**KIRKLEES METROPOLITAN COUNCIL  
INVESTMENT & REGENERATION SERVICE**

**DELEGATED DECISION TO DETERMINE PLANNING APPLICATIONS**

**Reference No:** 2019/62/91421/W

**Description:** Erection of extensions and alterations to stable/store to create dwelling forming annex accommodation associated with Highfield House, 63, Helme Lane, Meltham, Holmfirth, HD9 5PE

1 Site Layout / Block Plan
1 : 200

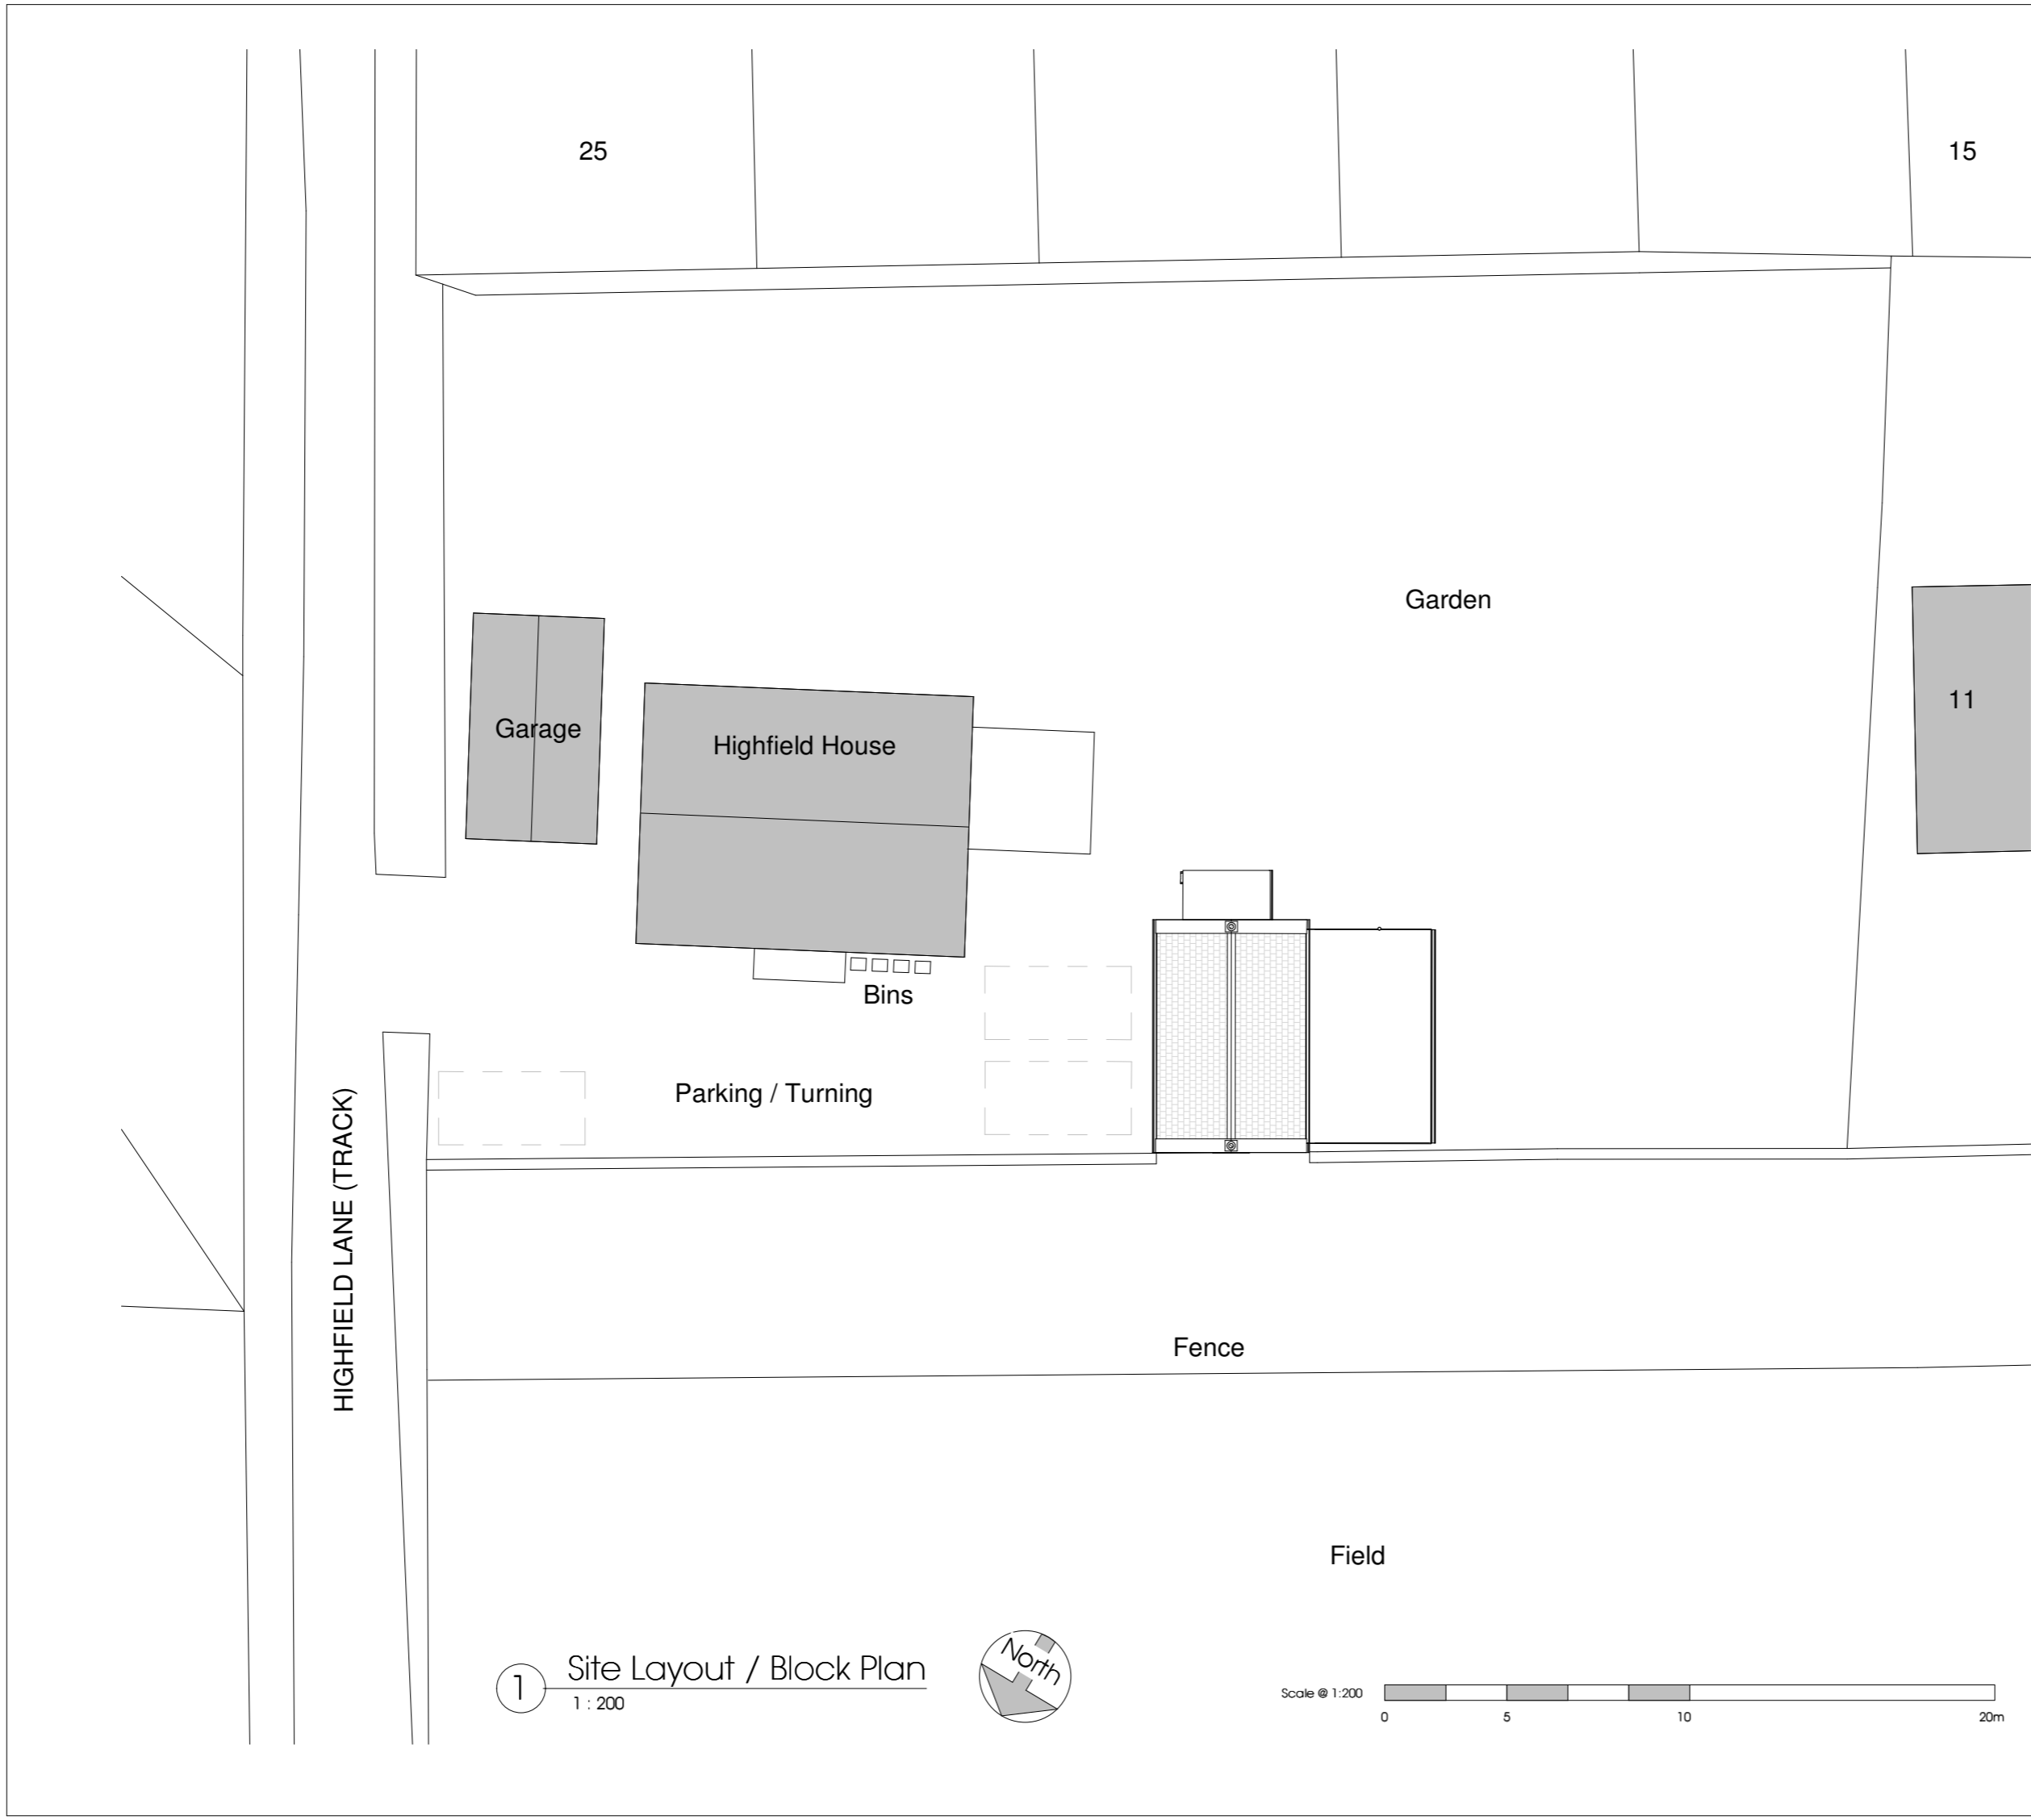
Car parking, bin storage and location of the electric vehicle charging point have now been shown on the block plan along with the location of where the nesting bird habitat is to be incorporated into the development as stated in the recommendations on page 10 of the submitted bat roost assessment, to avoid any discharge of conditions. The final revised plans received on 25<sup>th</sup> September 2019.

Policy LP21 of the Local Plan requires development proposals to be accessed effectively and safely by all users, and states that new development will not be permitted if it adds to highway safety problems. On assessment of the proposals, the Highway Officer initially requested that bin storage and parking for both the existing and proposed annexe be shown on the site block plan. A revised site block plan is now received including these details. It is assumed that the collections will be made as current, as such it was not considered necessary to seek further details nor impose the condition suggested by the Highway officer.

4. Prior to the occupation of the hereby approved annexe, the car park spaces to serve both the existing dwelling and approved annexe as shown on drawing no. 9001 revision P04 shall be marked out and made operational and thereafter retained in accordance with these details.

5. Prior to occupation of the hereby approved annexe one electric vehicle recharging point shall be installed within the vicinity of the car park spaces as shown on drawing no. 9001 rev P04. Cable and circuitry ratings shall be of adequate size to ensure a minimum continuous current demand of 16 Amps and a maximum demand of 32Amps. The electric vehicles charging point so installed shall thereafter be retained.
